From: Anita Gardner
Sent: 08 February 2018 09:04
To: Karen Parsons
Subject: FW: AB/143/17/L and AB/142/17/HH - 7 Old Poor House Cottages, Mount Pleasant, Arundel

The proposal site is within Arundel Conservation Area, and is Grade II Listed Wash-house to the historic Poor House complex.

The proposal is to introduce an upper floor, and insert ground floor bathroom. This requires removal of walls, whose age has not been ascertained and removal of concrete (non historic) floor to allow bathroom to issue into living room at one level. The insertion of the upper floor requires removal ground floor (historic) ceiling to lower the floor level to achieve head height at first floor level. Insertion of staircase, requiring removal of original floor and joists. This stair would pass directly in front of ground floor window. The proposal is to lower the GF ceiling/FF

EXISTING AND PROPOSED CROSS SECTION

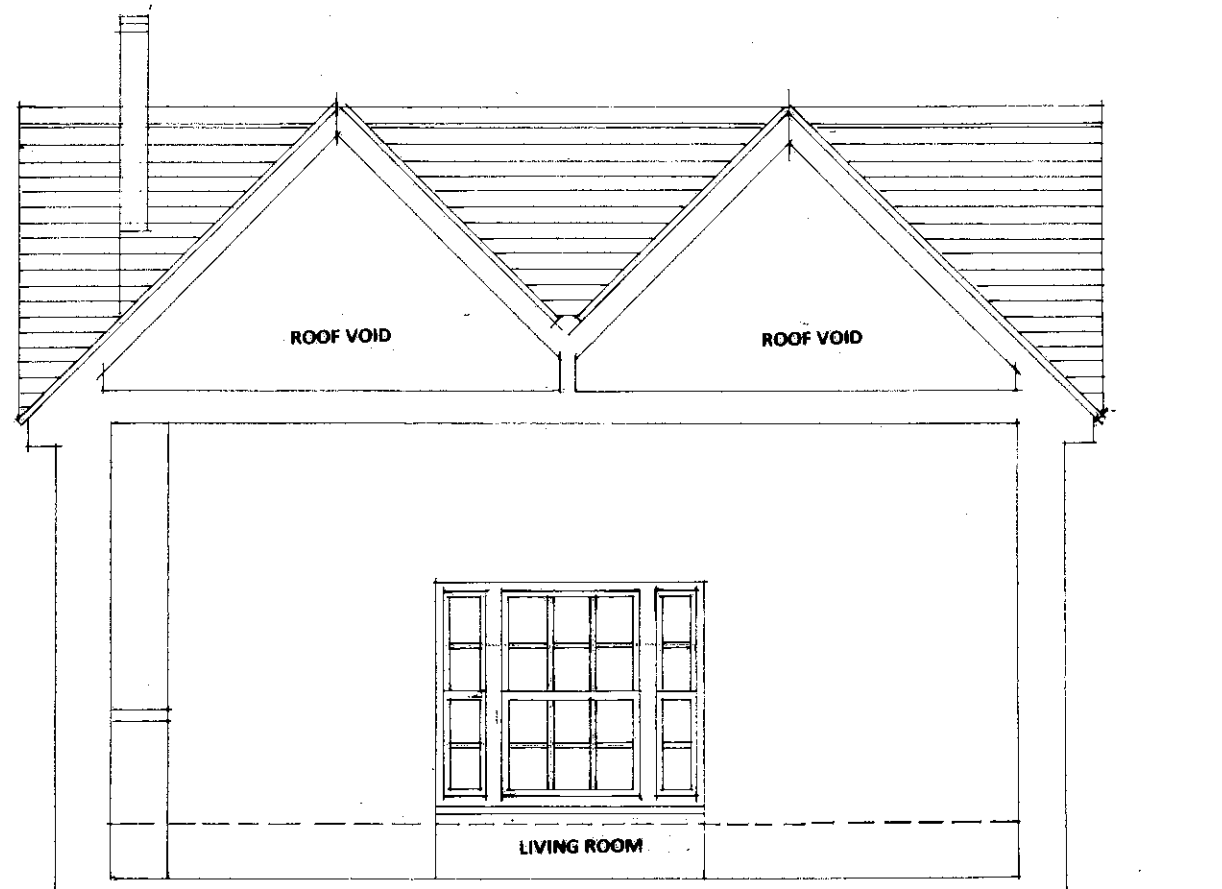
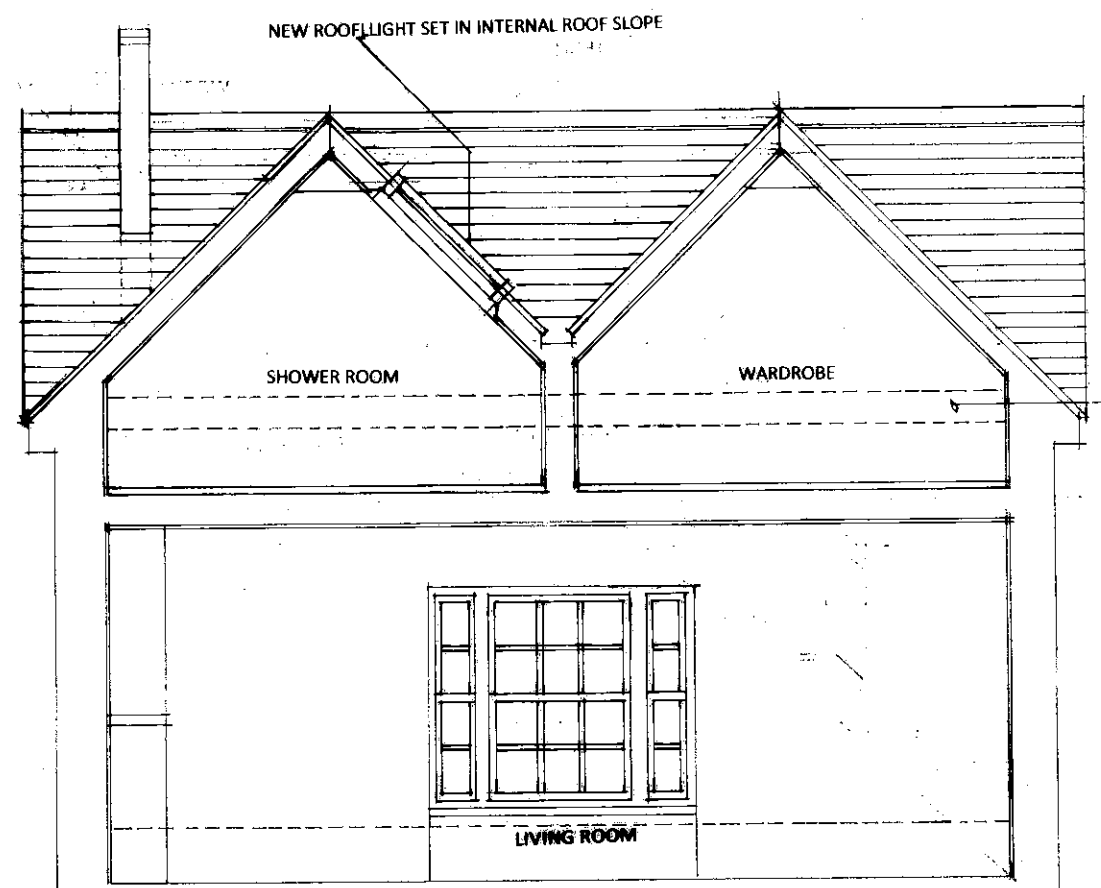
floor level. This would result in the floor joists appearing/crossing the window. It is not clear how the applicant wishes to address this element to achieve BRegs, in a satisfactory manner suitable for a Listed Building. It is proposed to insert a dormer window to first floor, requiring removal of historic fabric, removing the balance of visual symmetry, representing intrusion to the intended roofline and is detrimental to the street scene as atypical of a single storey building of this type.

**PROPOSED NORTH WEST ELEVATION
TO PARKING AREA**

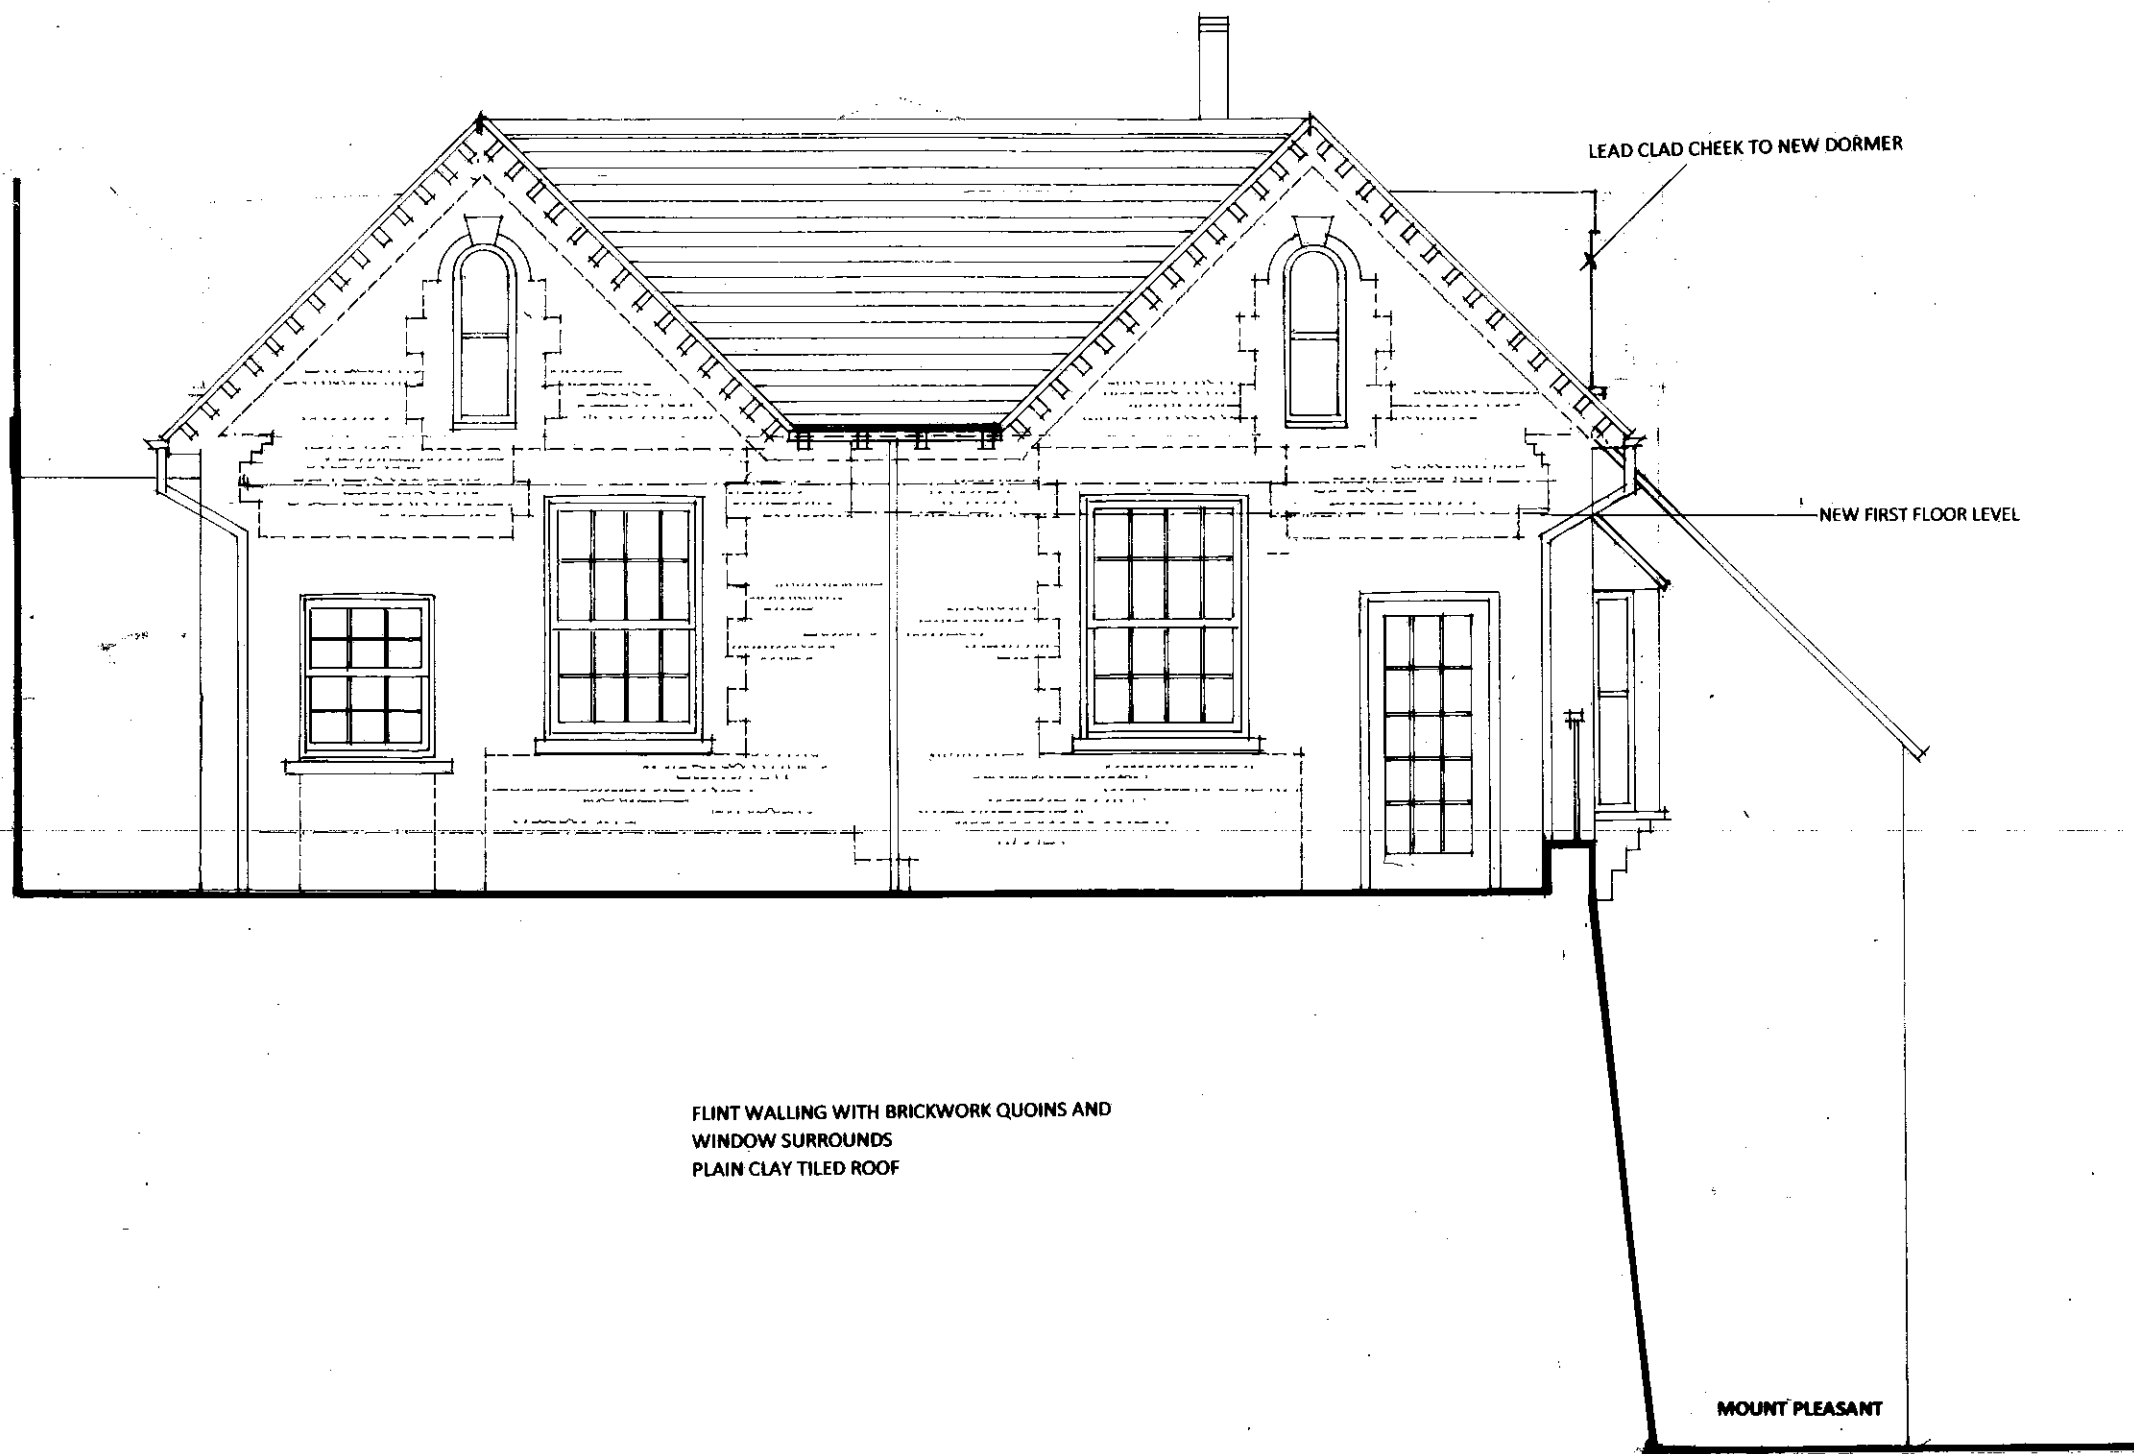
- It is considered that the proposal fails to respect or enhance local distinctiveness, and is detrimental to the street scene.
